Application for Planning Permission for Works or Extension to a Dwelling

Development: Proposed rear first floor extension.
Location: Fairholme Barnham Road Eastergate PO20 3RS

Existing East Elevation

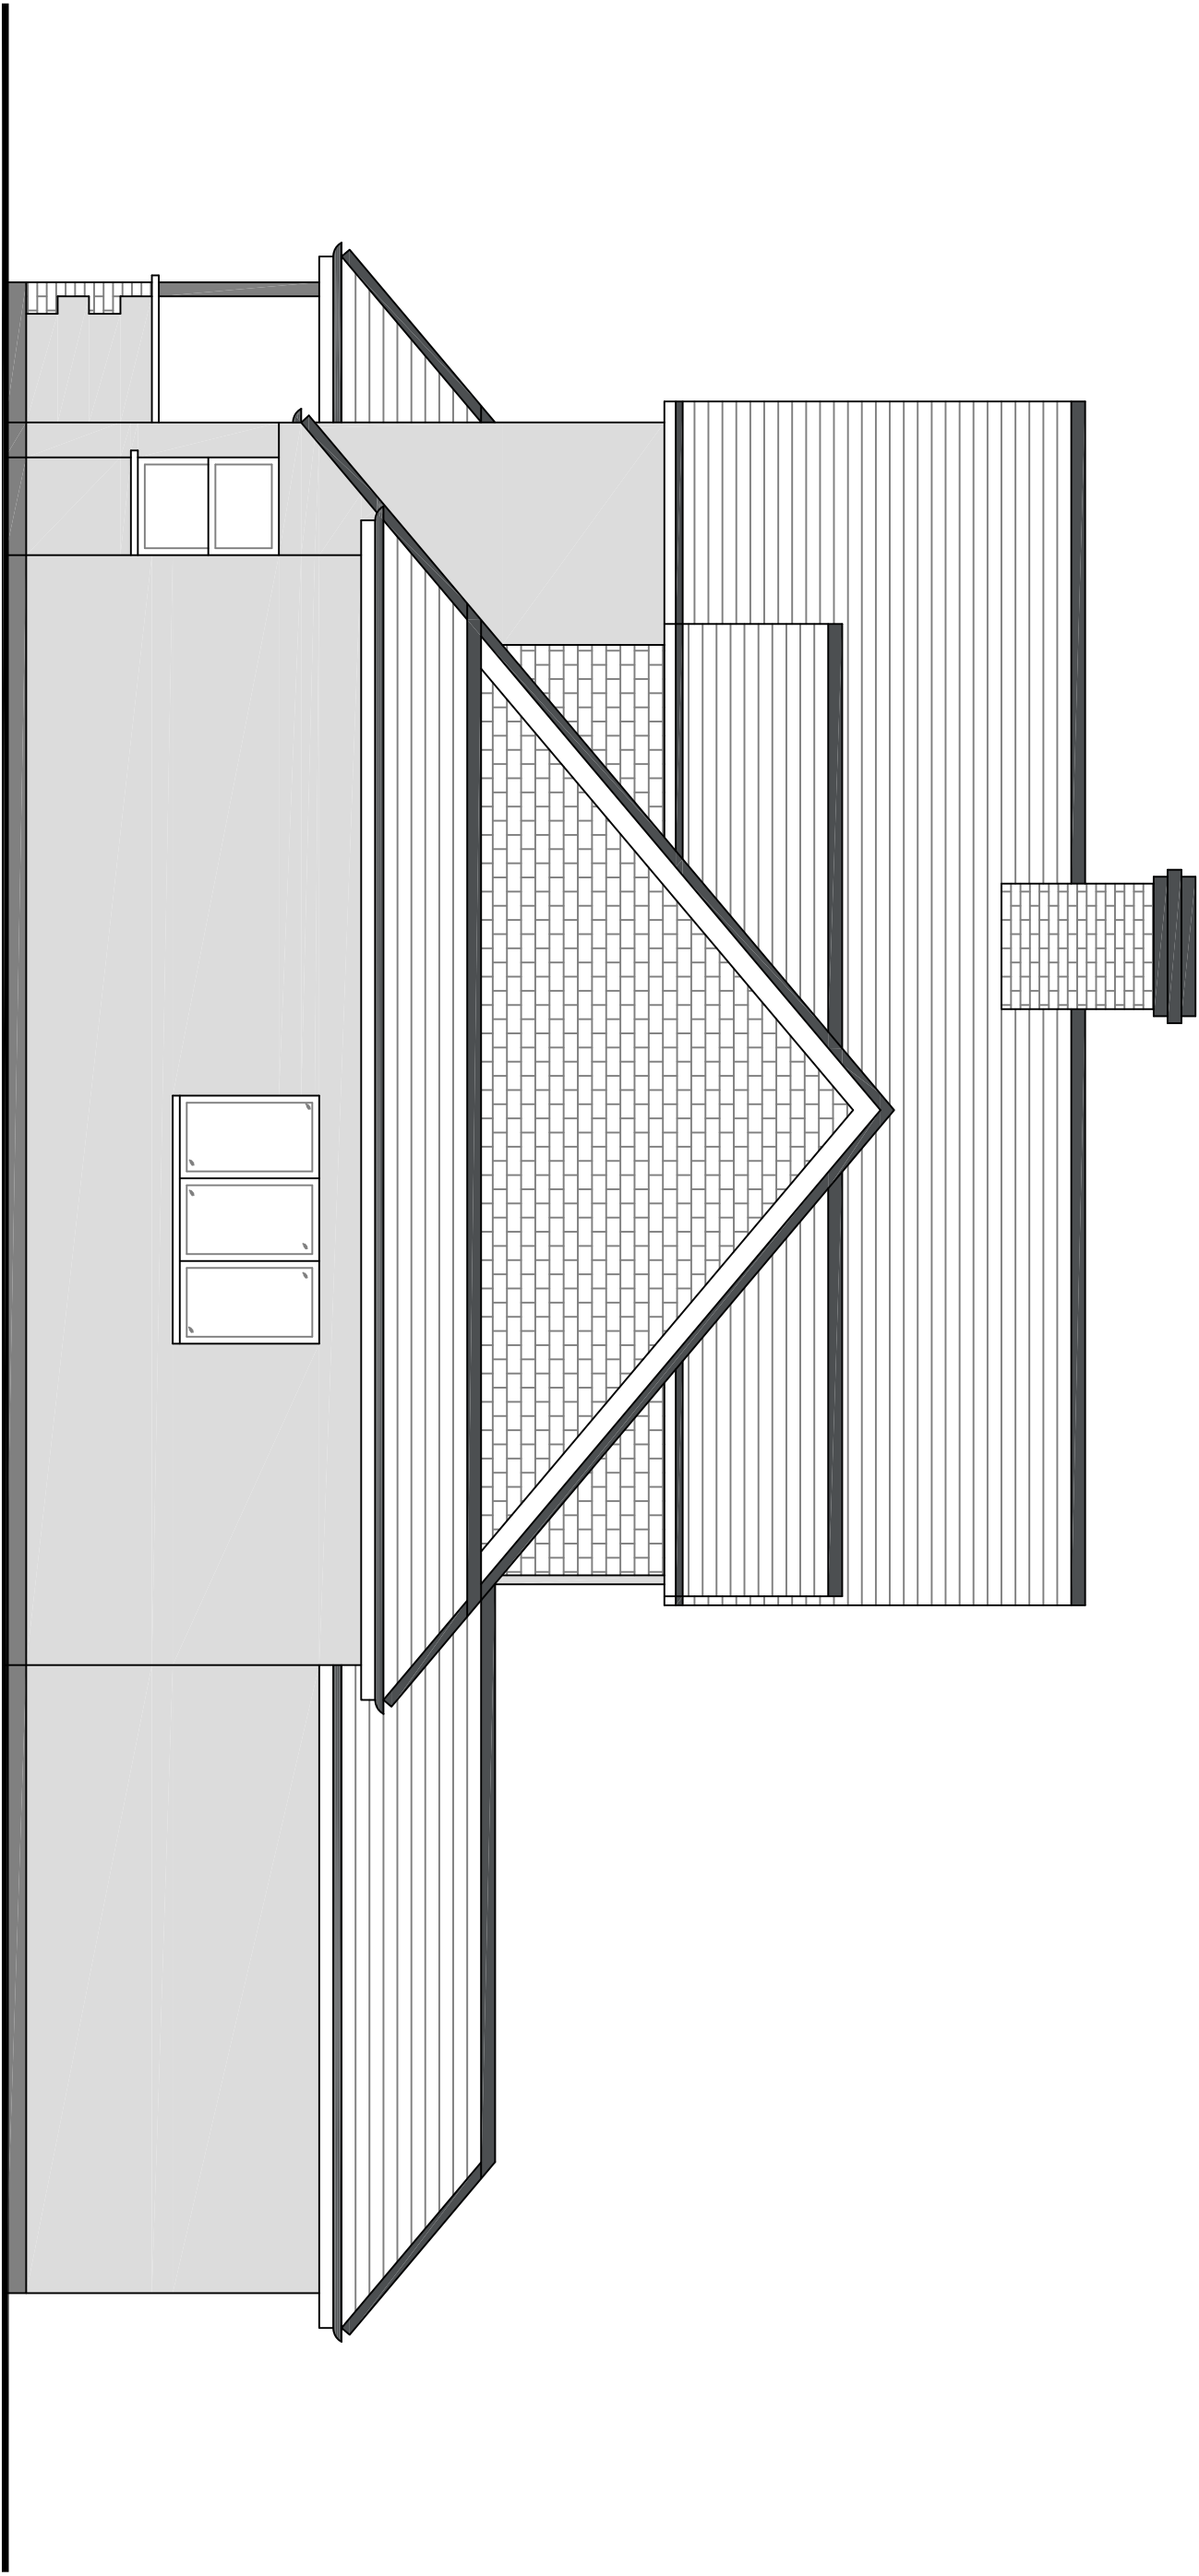
There are inconsistencies with fenestrations between the existing east elevation and existing ground floor plan. The inconsistencies are also between the proposed east elevations and proposed ground floor plan.

Existing First Floor Plan

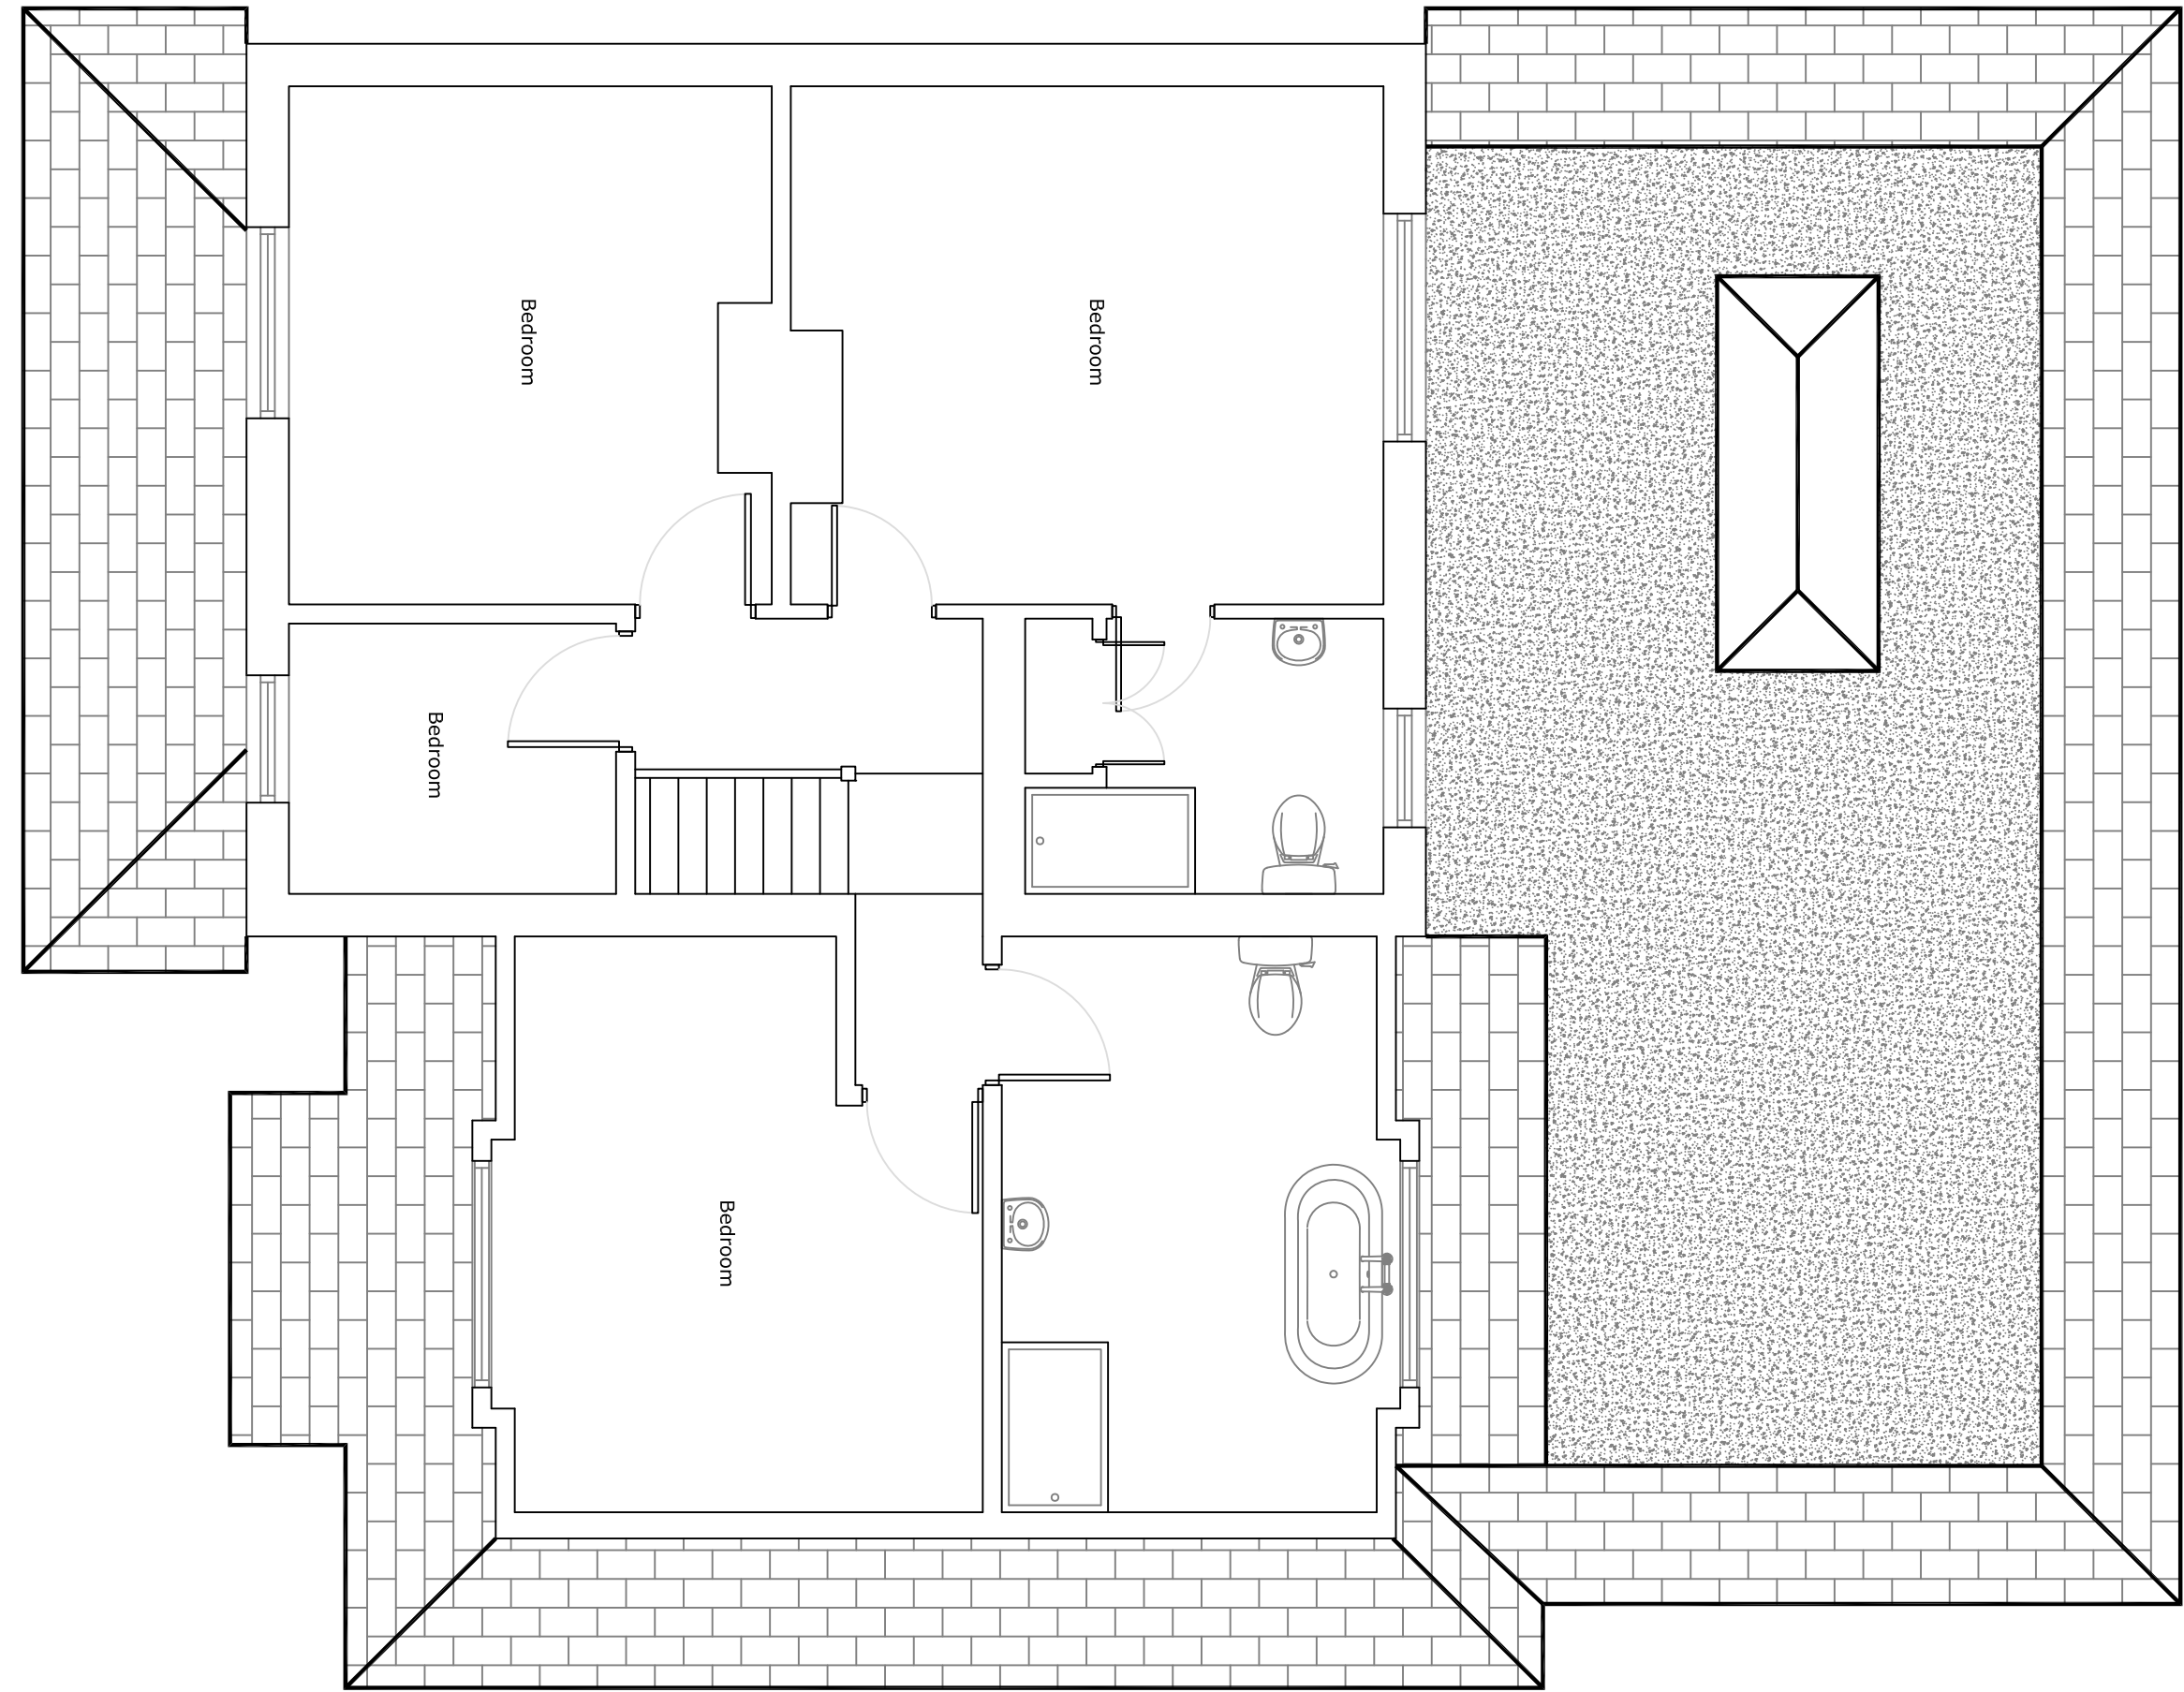
The proposed and existing floor and elevation plans require scale bars. Scalebars and scales need to clearly show which plan they belong to.

Site Location

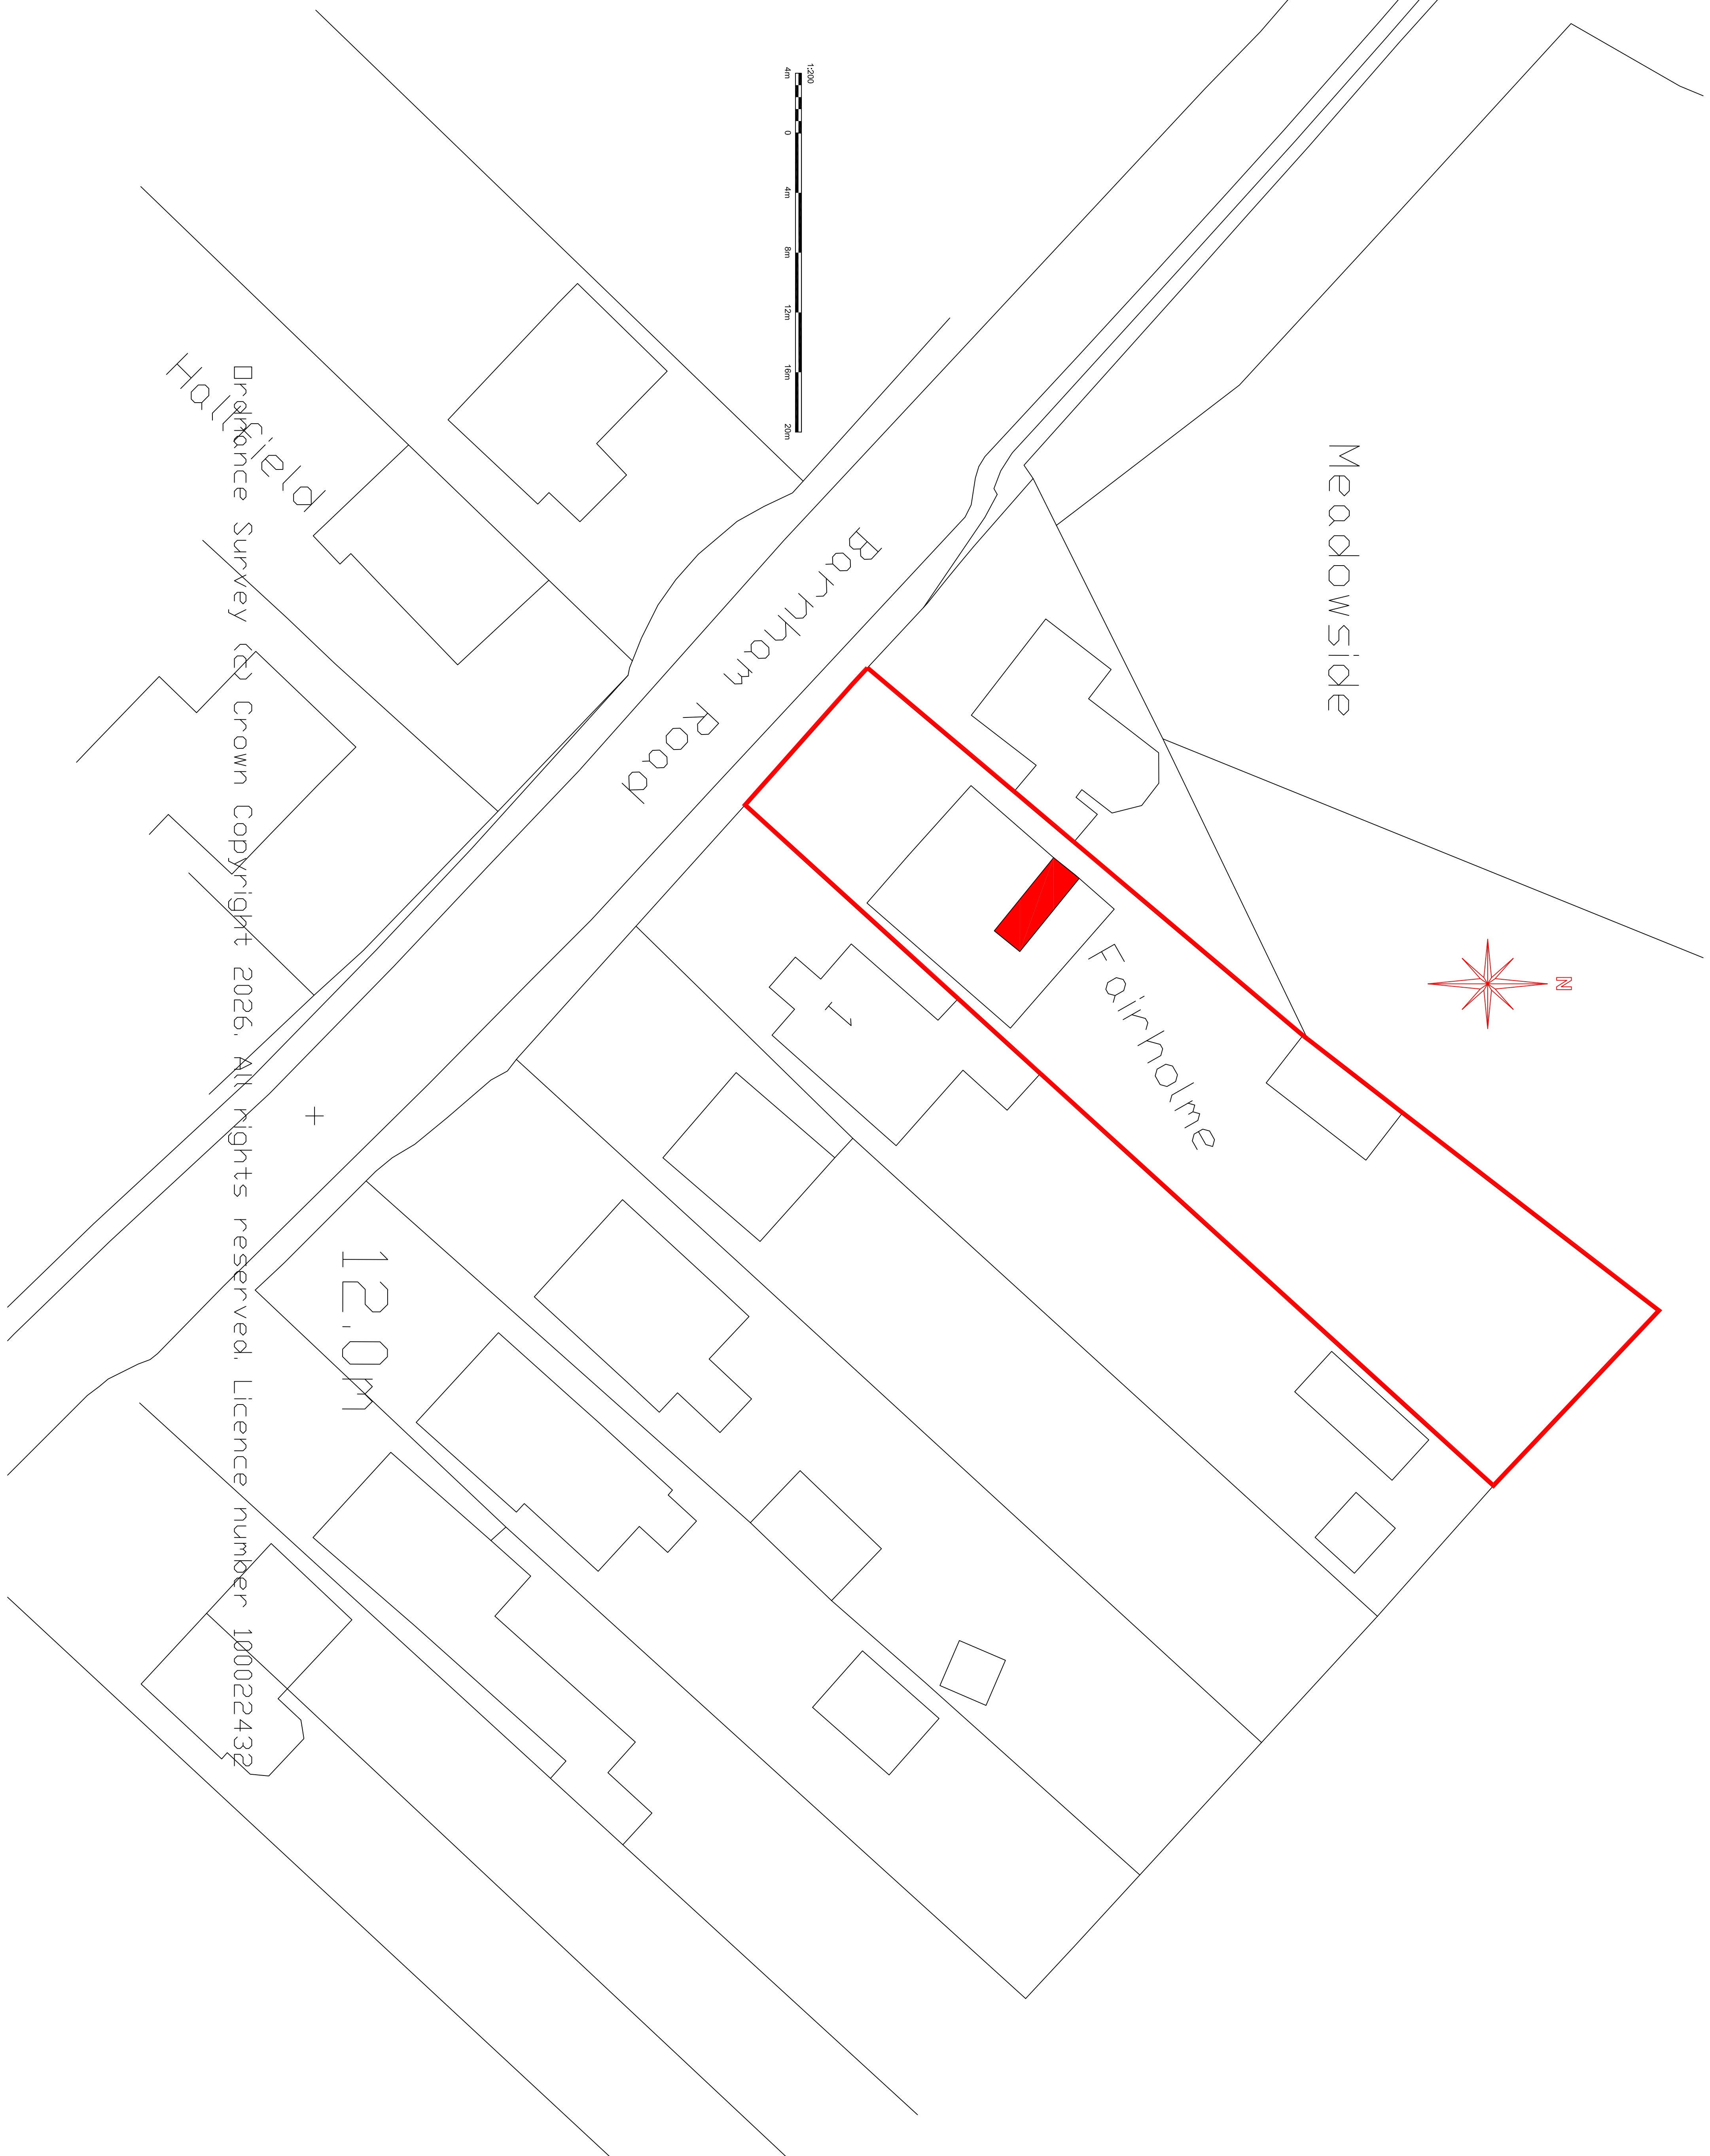
Scale bars are required on the location plan for both scales provided- The plan needs to clearly show which scale is for which plan.
